Our Ref: A/107/26/NMA

**Section 96A of the Town & Country Planning Act 1990 (as amended)
Town and Country Planning (Development Management Procedure) (England) Order 2015
(as amended) - Article 10**

Non material amendment following the grant of A/256/21/RES (as amended) relating to amendment of approved single and double car ports on plots 507, 523, 524 to single (507) and double (523, 524) garages respectively.

Land North of Water Lane Angmering

Ground Floor Plan
Plots 117/118, 154/155,
473/474, 478/479 & 523/524

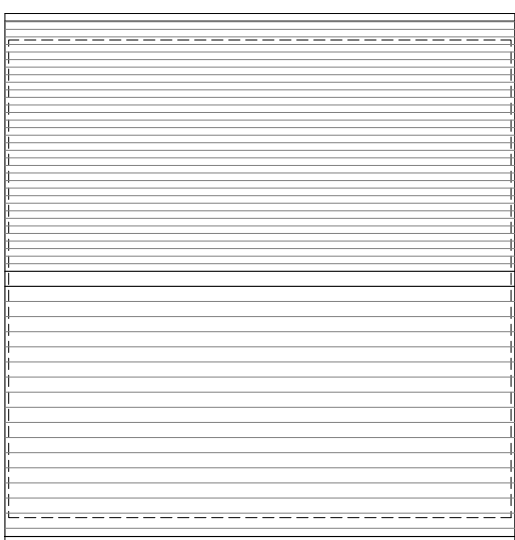
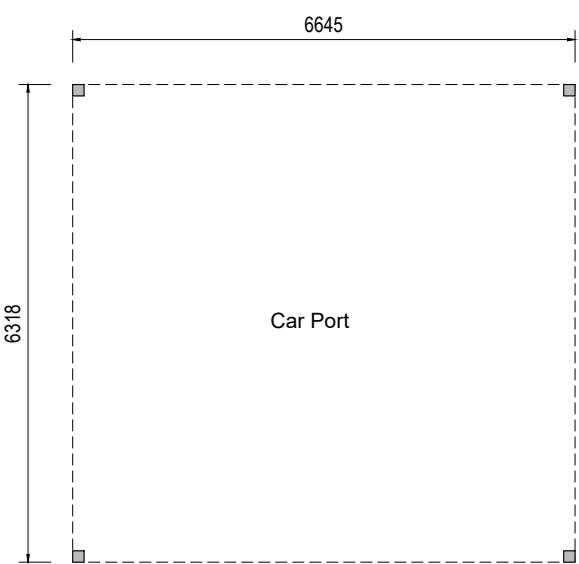
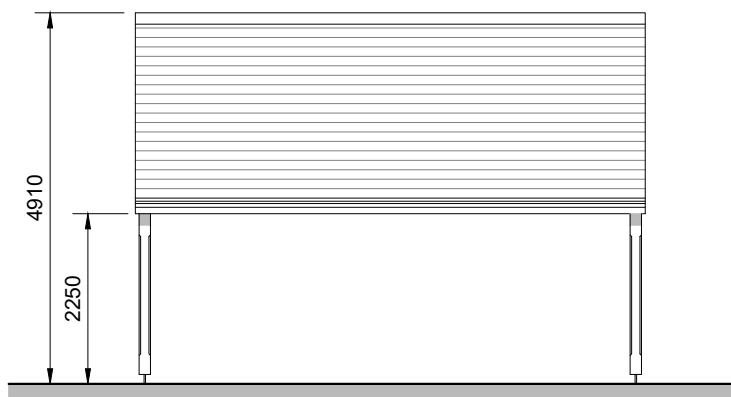
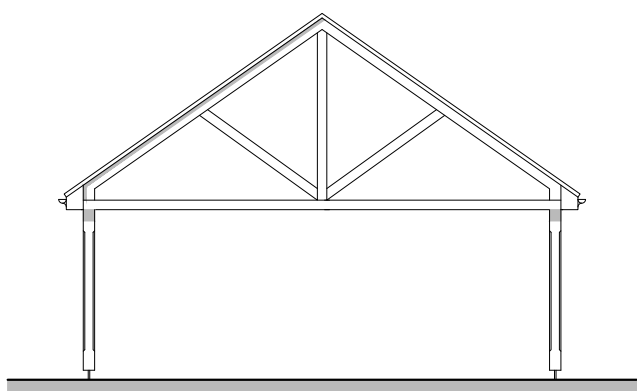
However, in relation to parking provision, paragraph 2.19 of the Arun Parking Standards SPD states that a car port counts as one parking space, whereas a garage counts as only 0.5 parking spaces. The proposed conversion of the car ports to garages would therefore reduce the parking provision by 0.5 spaces for each of the three dwellings.

The impact of this reduction on parking availability, future occupiers and the local highway network would require assessment by the Highway Authority. As a result, the proposed amendment would have material planning implications and could only be considered through a Section 73 application.
